****Issued Permit** 58 Vannah**

RE: PERMIT #2016-01983

SHED
ELEVATION GABLE END NORTH (BACK YARD)

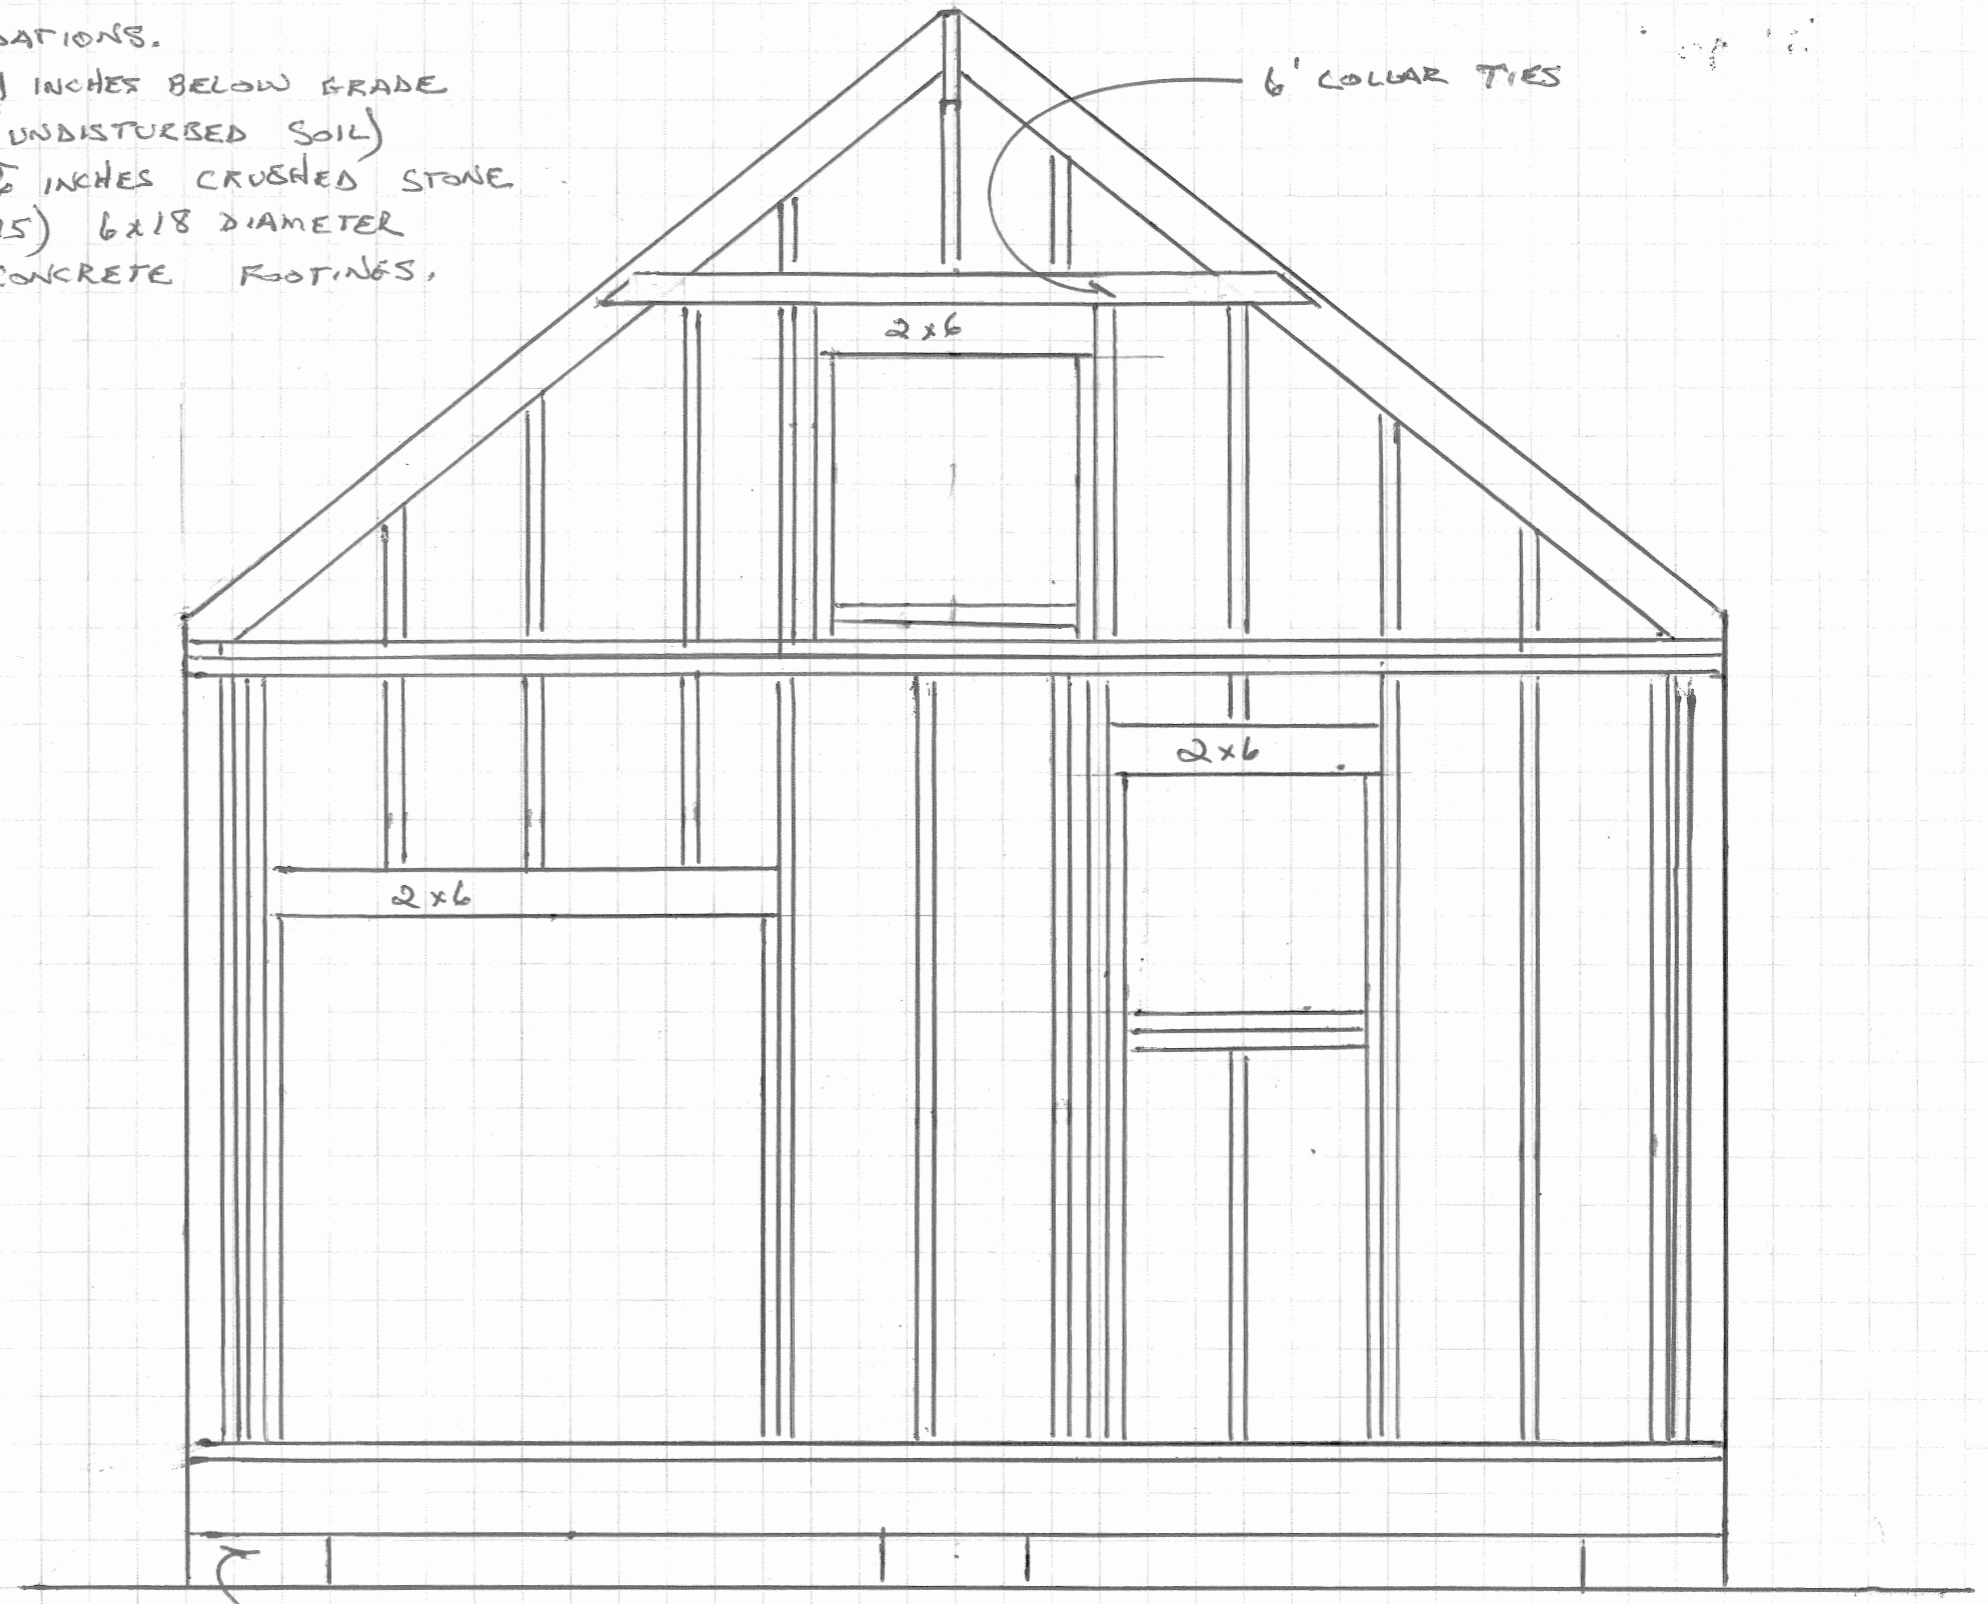
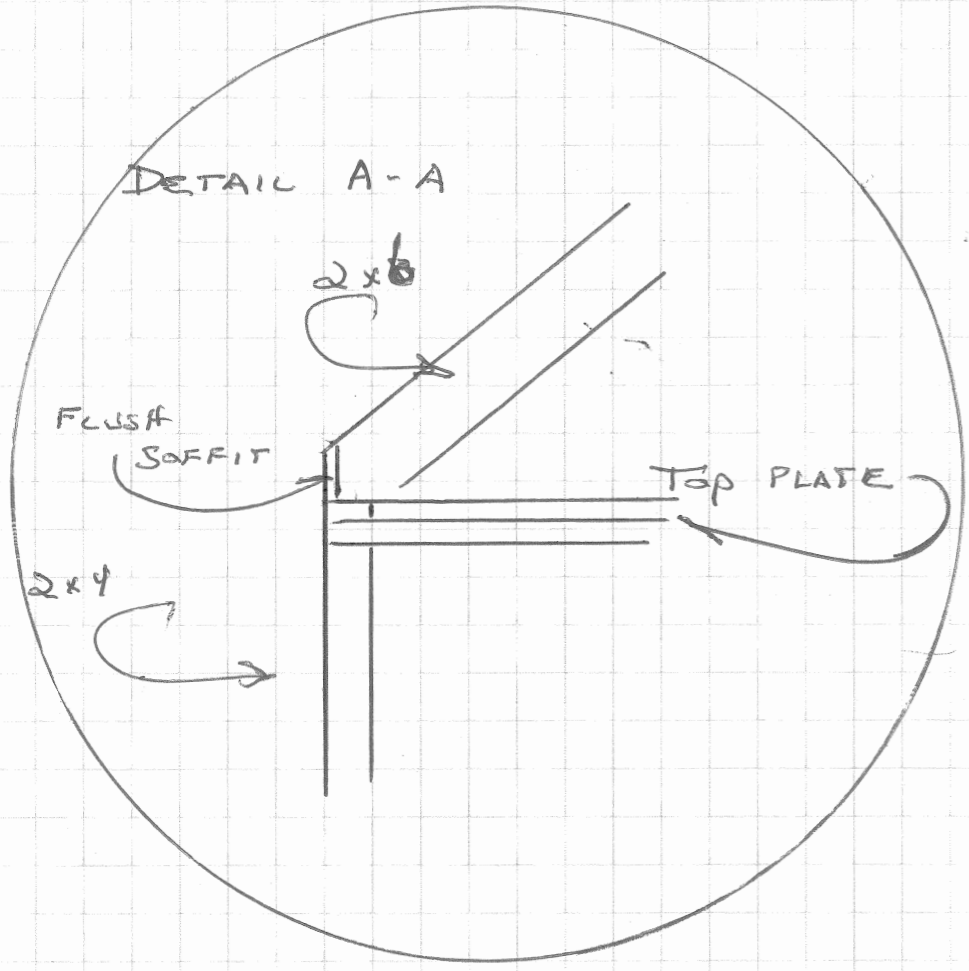
Also there was a typo entered on Page 10 of 14 (Detail A-A) and Page 12 of 14.

Both pages call out rafters of 2 x 6. The rafters are going to be 2 x 8 with a 2x10 ridge board.
